Our ref: NO/2023/115204/01-L01
Your ref: 3/2022/1156
Date: 28 April 2023

**PROPOSED EXTENSION TO VILLAGE HALL TO FORM A SINGLE STOREY REAR STORAGE ROOM.
BOLTON-BY-BOWLAND COMMUNITY HALL, MAIN STREET, BOLTON-BY-BOWLAND, CLITHEROE, BB7 4NW**

Bolton-by-Bowland Village Hall
Storage Room Floor Plans
Scale 1:100 @ A3

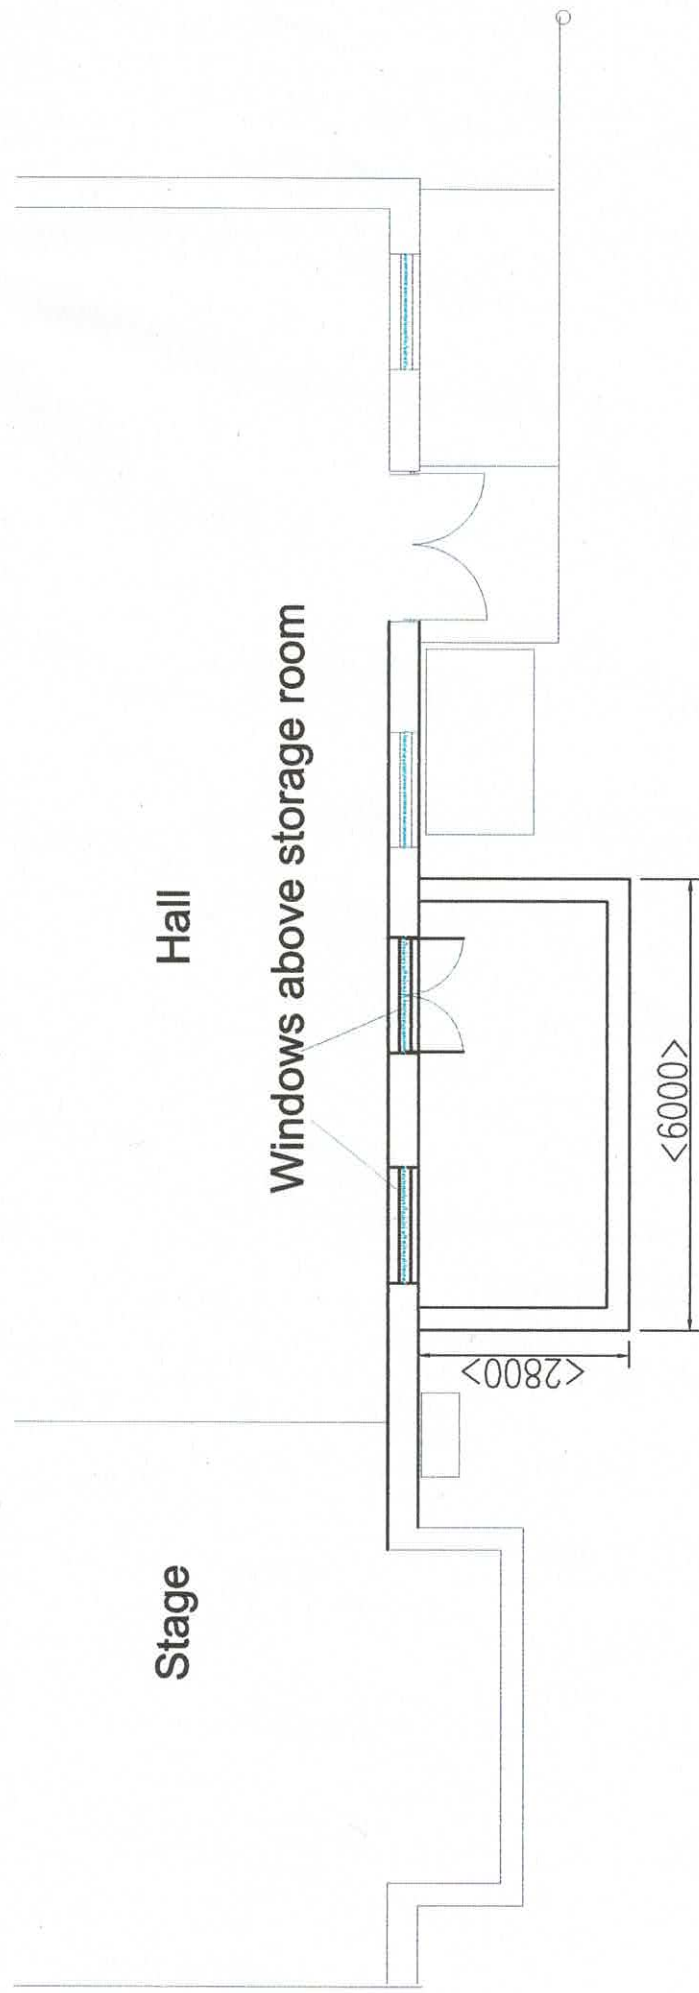
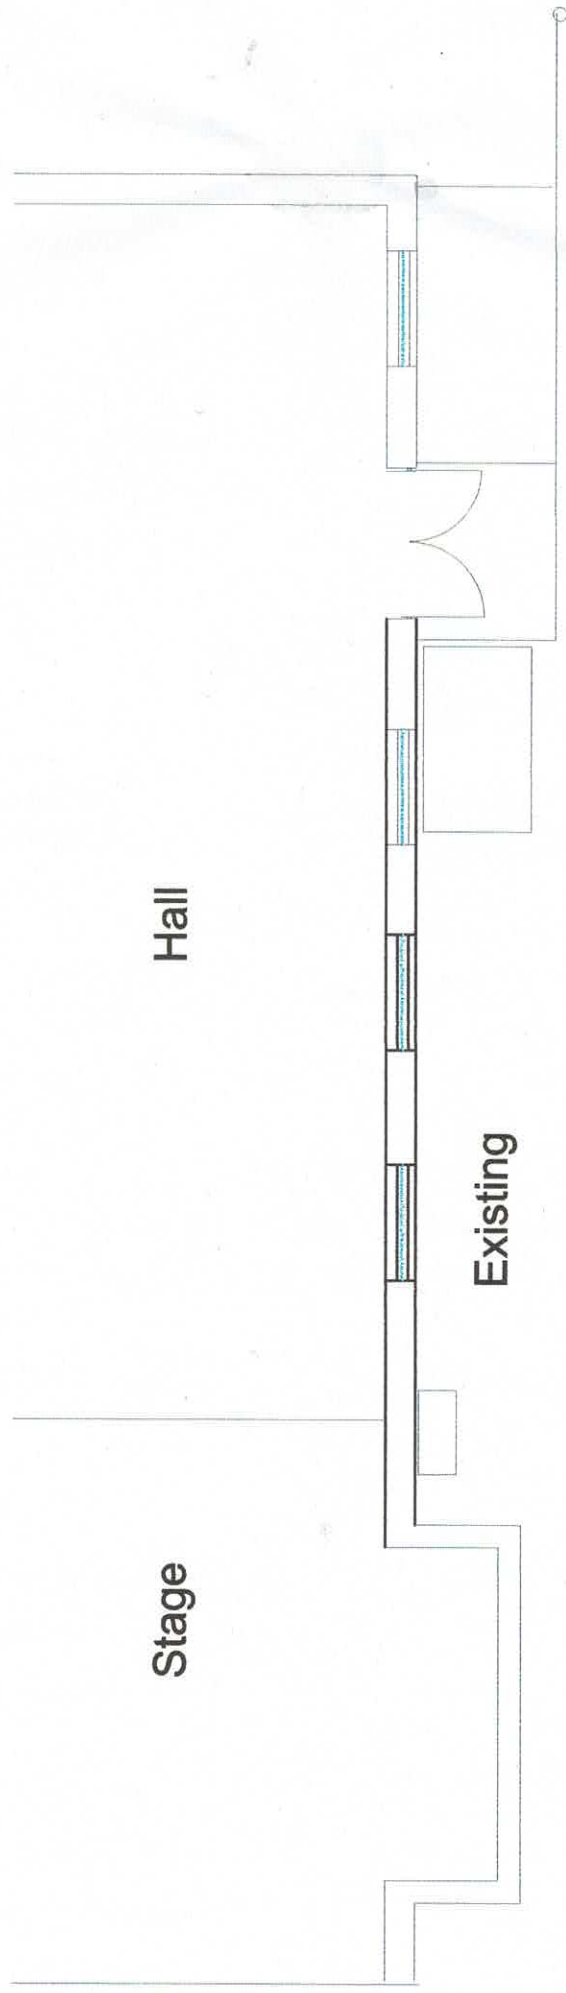
We object to this application as it involves building works within 8 metres of a watercourse/ flood defence. As submitted, it is unlikely that we would grant a flood risk activity permit for this application.

- The proposed development would restrict essential maintenance and emergency access to the watercourse/ defences. The permanent retention of a continuous unobstructed area is an essential requirement for future maintenance and/ or improvement works.
- The proposed development would obstruct flood flows, thereby increasing the risk of flooding in the vicinity.
- The proposed development is likely to adversely affect the construction and stability of the flood defence which will compromise its function, this could in turn increase flooding to the surrounding land.

The applicant should relocate the proposed extension to a part of the building away from the flood defence. Alternatively, the applicant must satisfy us that the construction of the proposed extension is not likely to adversely affect the construction and stability of the flood defence or compromise its function. The applicant must also satisfy us that our statutory right of access will not be negatively affected by the proposed development.
